26 July 2011

Kimbriki Resource Recovery Project Response to Submissions Report

This letter is to address responses to the Submissions Report for the Kimbriki Resource Recovery Environmental Assessment (EA) from the following:

**Figure 1** Revised project footprint

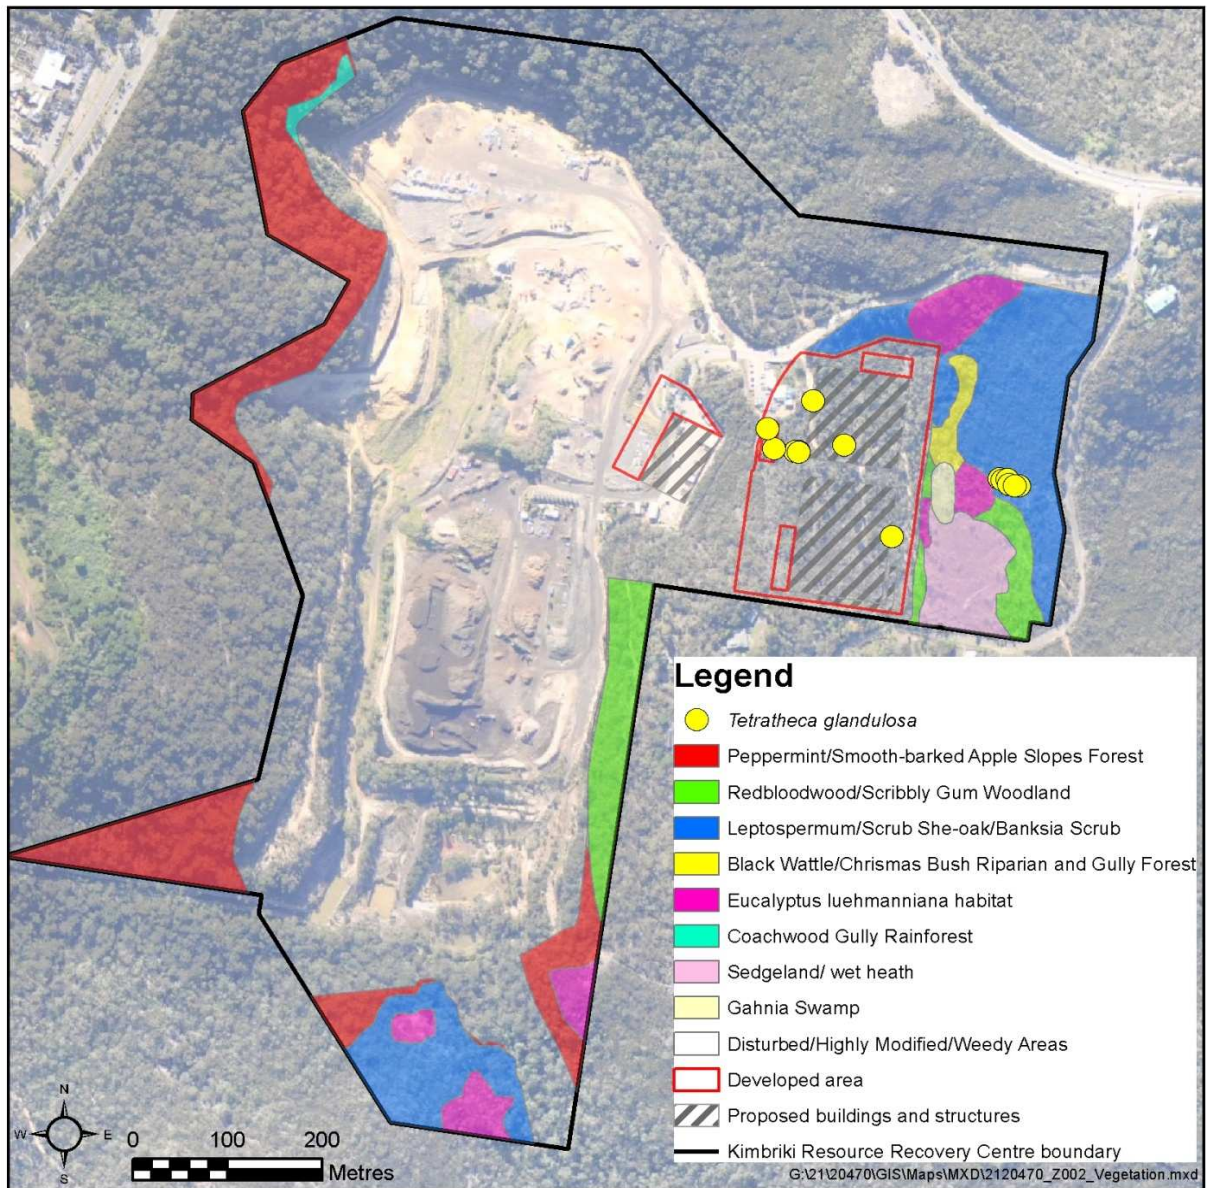
It is recommended that the Determination for the EEC needs to be made before the project is approved, or the Department of Planning and Infrastructure needs to verify if it is possible to relocate the proposed buildings/proposal away from the upland swamp on the site and avoid potential impacts.

A “wetland” is considered to exist within the developed portion of the site (ie at the location of the proposed Amenities block).....It is recommended that the development be sited clear of the identified riparian corridor.

In terms of the Gahnia Swamp assemblages, the Submissions Report (SR) stated that 0.13 ha or 8% of the proposed EEC would be removed by the proposal, but that 1.58 ha would be retained and managed in a protected offset area. In response to NOW's request to relocate the proposed buildings/proposal away from the upland swamp on the site and avoid potential impacts, KEE has decided to reduce the footprint of the platform by eliminating the proposed amenities and office building, which would now be incorporated within other buildings on the site. This retains the 8% of the Gahnia swamp area that would have been affected by the proposal. The revised platform footprint is shown on Figure 1.

It is noted that the reduced area of the platform (refer Figure 1) will also reduce the amount of rain water that falls on the platform, and shift the balance closer to the natural flow system.

There is insufficient non filled land on the entire KEE site to relocate the maturation building without impacting on other significant vegetation, such as the area to the west of the building, containing specimens of the listed species *tetratheca glandulosa*. However, to reduce the impact on the EEC Coastal Upland Swamp, the amenities block has been deleted, as it is assumed that it can be incorporated within one of the other two buildings (refer Figure 1). This has reduced the impact on the drainage corridor and the EEC Coastal Upland Swamp species.

As described in Section 1 (on page 1), KEE decided to reduce the footprint of the platform in response to NOW's request to relocate the proposed buildings/proposal away from the upland swamp on the site. The adjusted platform area is shown on Figure 1. The additional vegetation retained as a result of this adjustment to the platform footprint adds to the overall ecological offset strategy.

**Figure 2 Formal offsets**

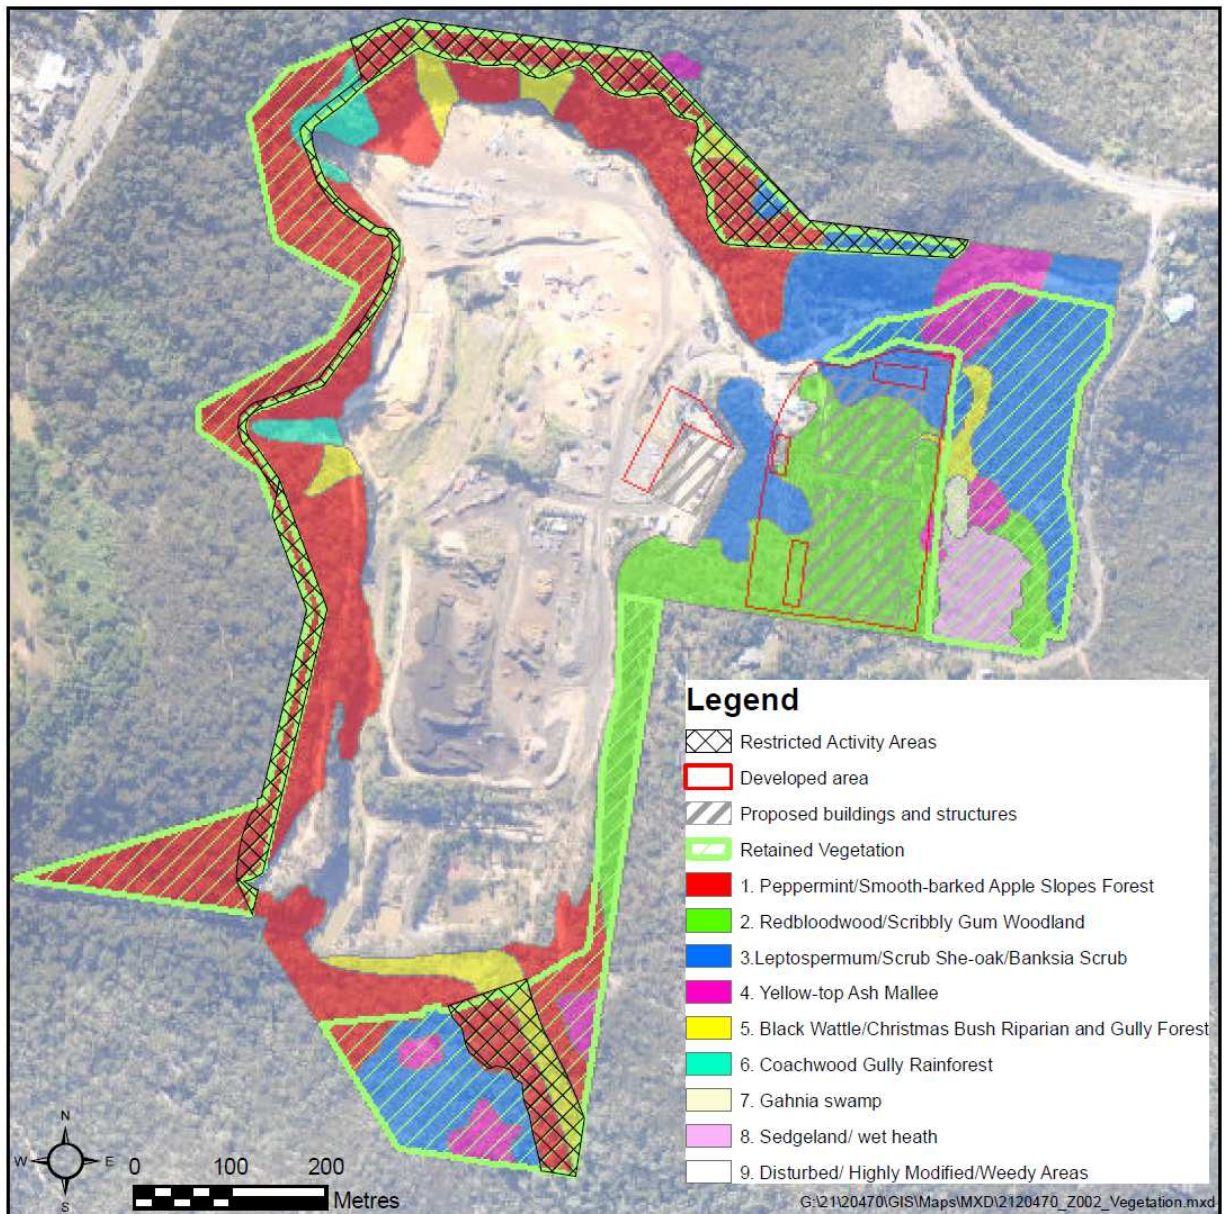
The Gahnia swamp and therefore the Coastal Upland Swamp is considered to extend an additional 30m north from that shown on Figure 1 – Drainage Path Vegetation Assessment in the Submission Report (KEE/GHD).

Ecotone, KEE's ecological consultant, has mapped the extent of the Coastal Upland Swamp, and it is shown on Figure 2, with the original platform layout. This shows how much of the swamp was affected by the original platform layout. It does not appear to extend an additional 30 m north of the area shown on Figure 1 in the SR.
